From: Janice Chapman [mailto:Janice.Chapman@arun.gov.uk]
Sent: 08 February 2011 16:43
To: [REDACTED]
Subject: M/5/11/NMA - Installation of two roof lights on the rear elevation and three roof lights on the porch roof on the front elevation - Amendment to approved planning permission M/6/09.

APPROVED UNDER m/6/09

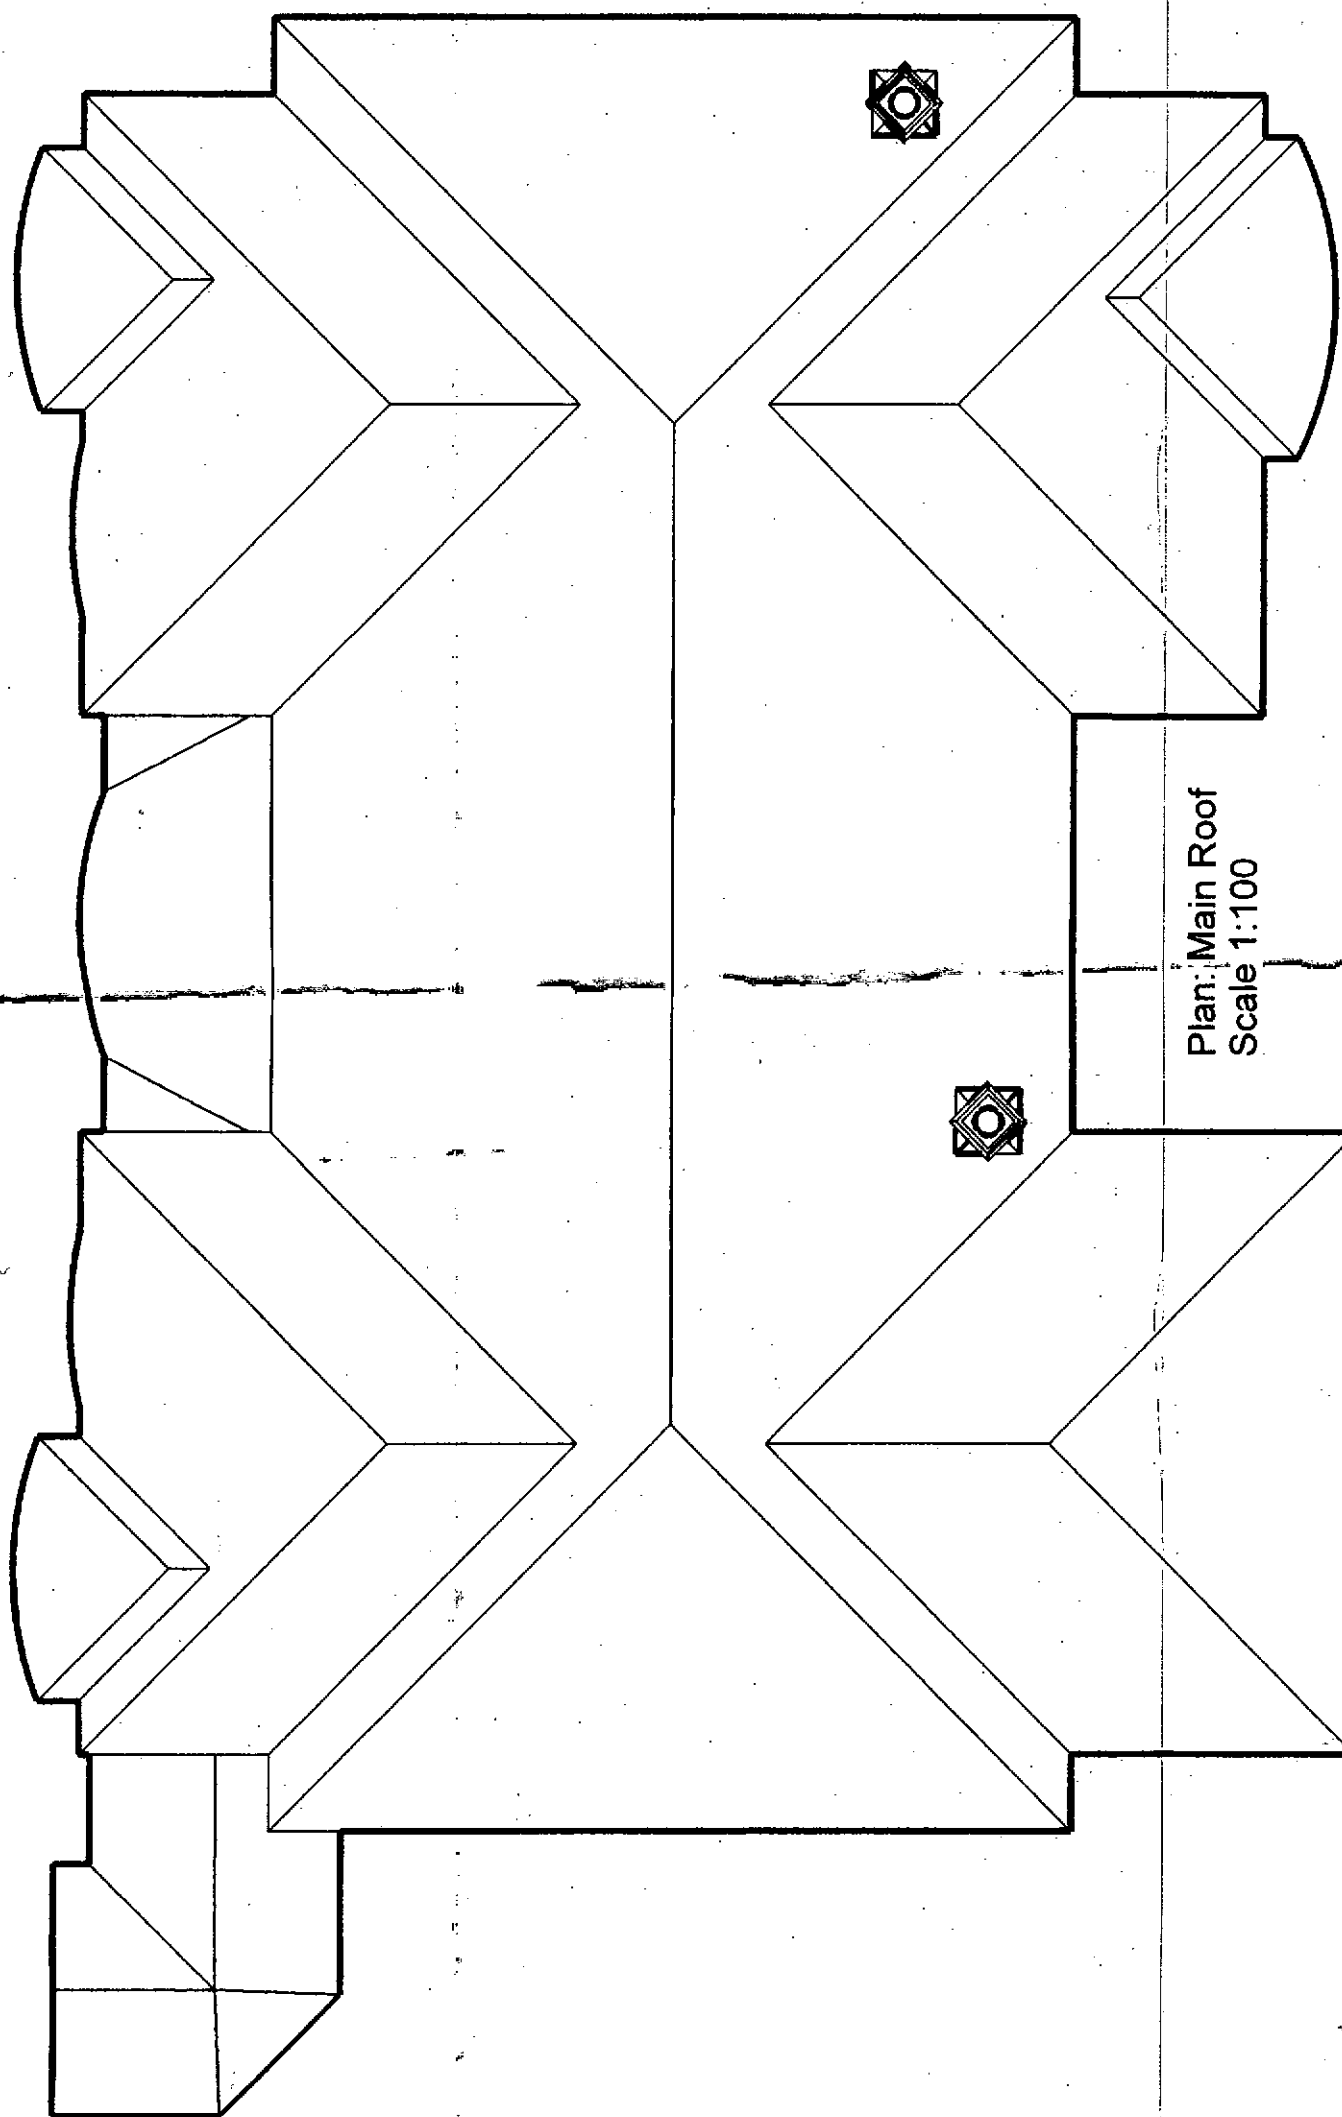
The rear elevation as approved under M/6/09 Drg No GRJ64SW 201 shows a chimney, has this been deleted.

The front porch as approved under M/6/09 Drg No GRJ64SW 201 differs from the plan submitted in design and now shows a substantial roof. To assess whether this can be accepted as a non material amendment I need to see a floor plan and side elevation showing the amended design.
